CITY OF MERCER ISLAND

July 18, 2016

RE: Request for Information - File Nos. SEP16-015/ZTR16-002
Mercer Island Center for the Arts
3205 77th Avenue SE
Mercer Island, WA 98040;
King County Tax Parcel # 1224049068

MERCER ISLAND CENTER FOR THE ARTS CONCEPTUAL MITIGATION PLAN

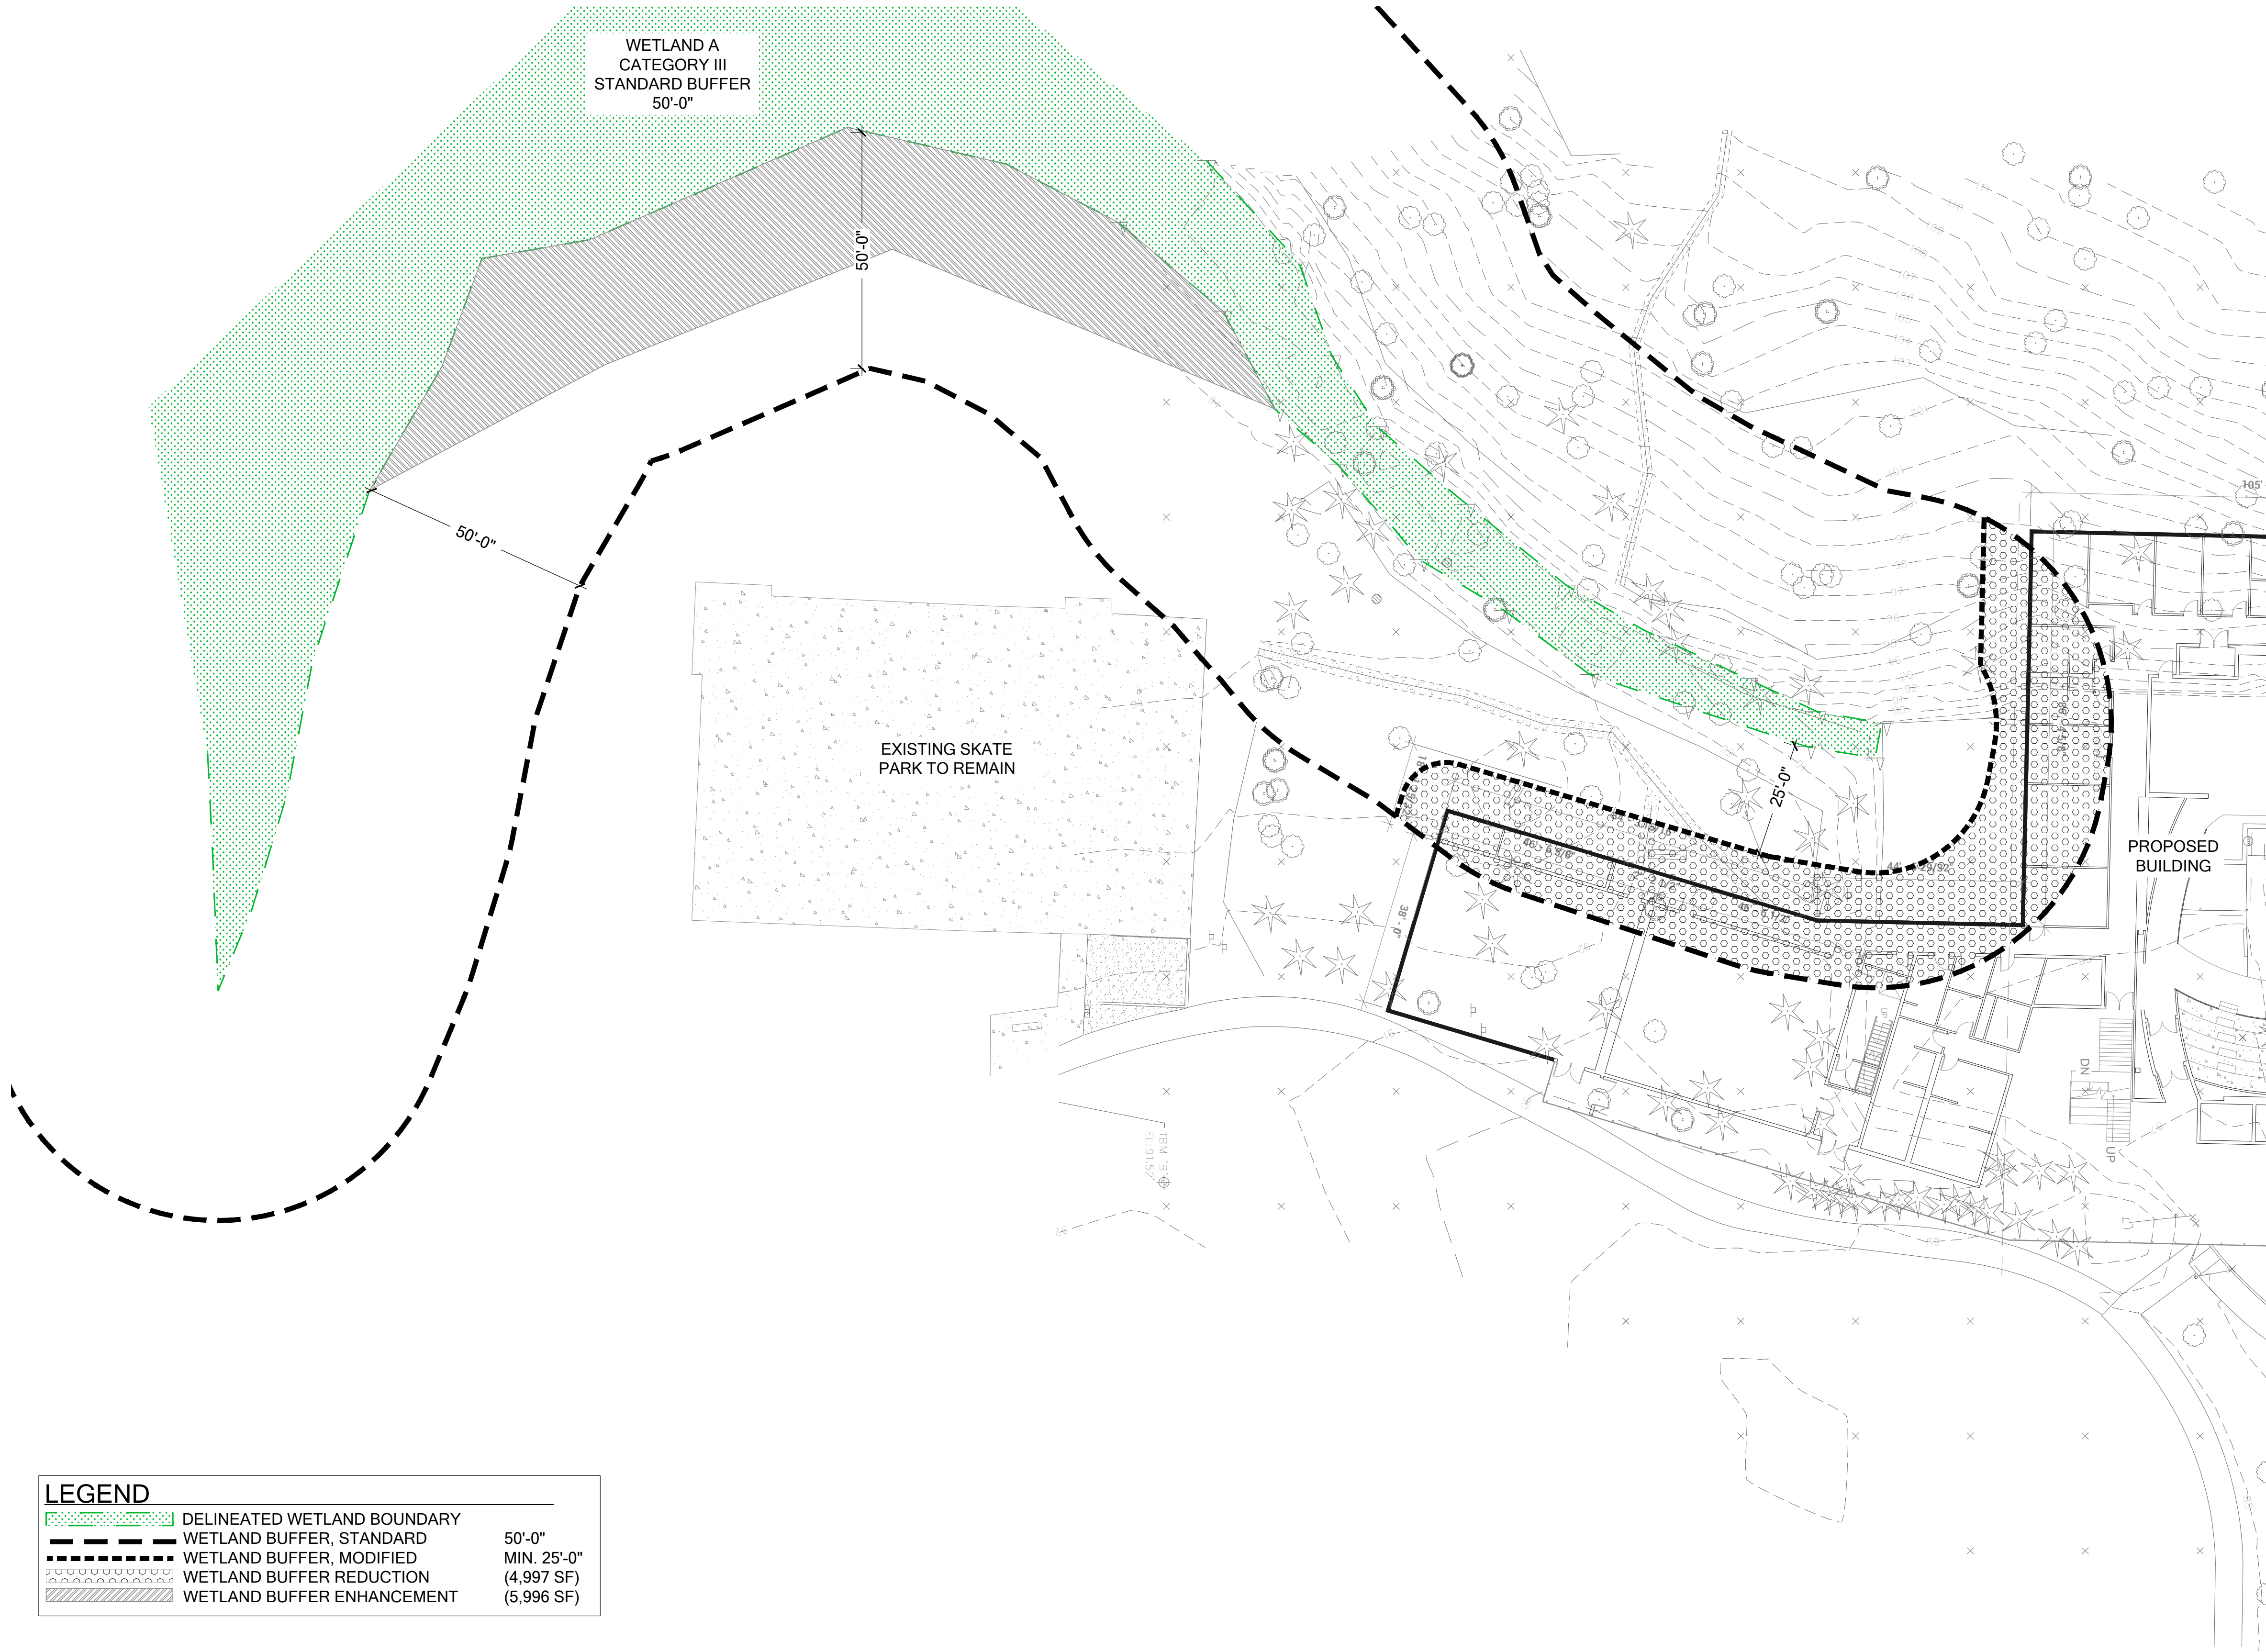
5. Attachments C and D (geotechnical information) need to be updated or supplemented to reflect the currently proposed plans.
6. Attachment F (wetland mitigation proposal) needs to be updated or supplemented to reflect the currently proposed plans and proposed mitigation.

1 SHORT PLAT
1" = 50'-0"

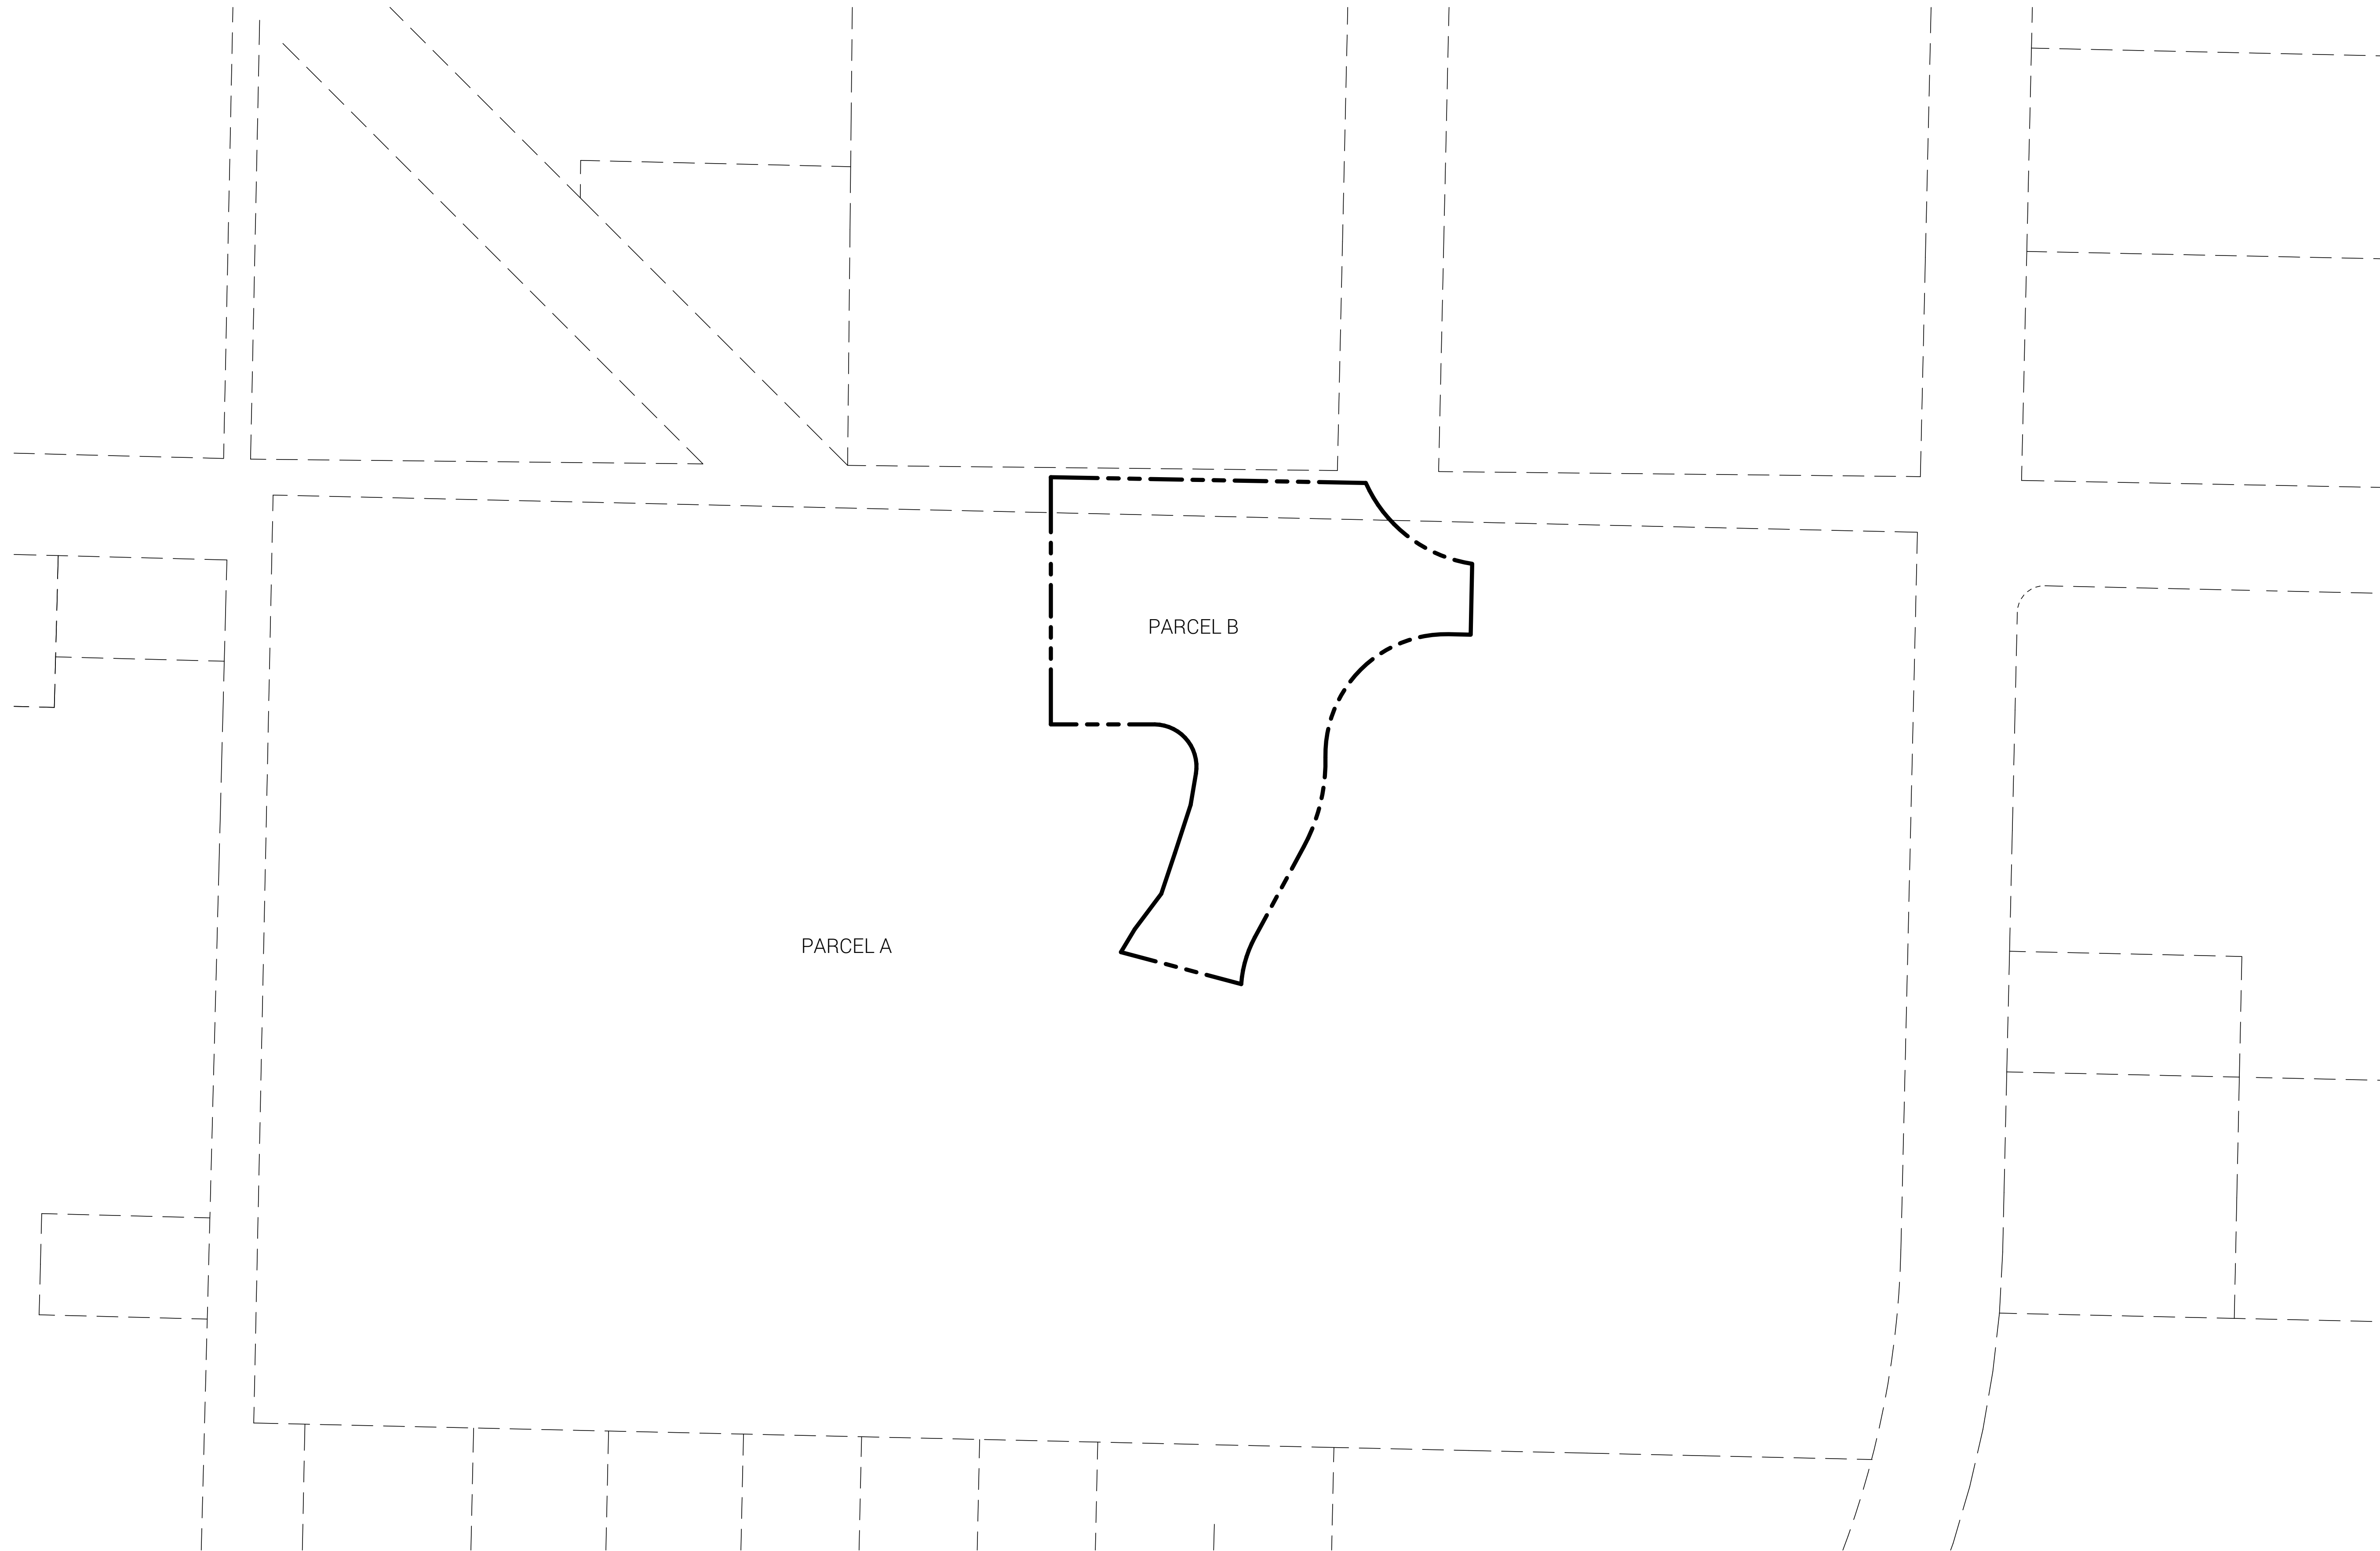
1. MICC 19.16.010 defines "subdivision" as: *"The division or platting of, or the act of division or platting of, land into two or more lots for the purpose of transfer of ownership, building development, or **lease**, whether immediate or future, and shall include all resubdivision of land."* (emphasis added) Please modify the submitted SEPA Checklist to include a short subdivision (short plat) as part of the project.
2. MICC 19.09.090 requires designation of a building pad for each lot in a short plat. The designated building pads need to be shown as part of the supporting materials for the SEPA Checklist to allow evaluation of any environmental impacts. Please submit supporting information showing how the proposed building pads comply with MICC 19.09.090:

MICC 19.09.090 Building Pads

A. Designation. New subdivisions must designate a building pad for each lot as follows:

1. The applicant must determine the location of a building pad by considering vegetation, topography, critical areas, and the relationship of the proposed building pad to existing/proposed homes. Access to the building pad must be consistent with the standards for driveway access contained in MICC 19.09.040.
2. Building pads shall not be located within yard setbacks, rights-of-way and critical areas or its buffers; provided, however, building pads may be located within landslide hazard areas when all of the following are met: (a) a qualified professional determines that the criteria of MICC 19.07.060(D), Site

Development, is satisfied; (b) building pads are sited to minimize impacts to the extent reasonably feasible; and (c) building pads are not located in steep slopes or within 10 feet from the top of a steep slope, unless such slopes, as determined by a qualified professional, consist of soil types determined not to be landslide prone.

3. No cross-section dimension of a building pad shall be less than 20 feet in width.
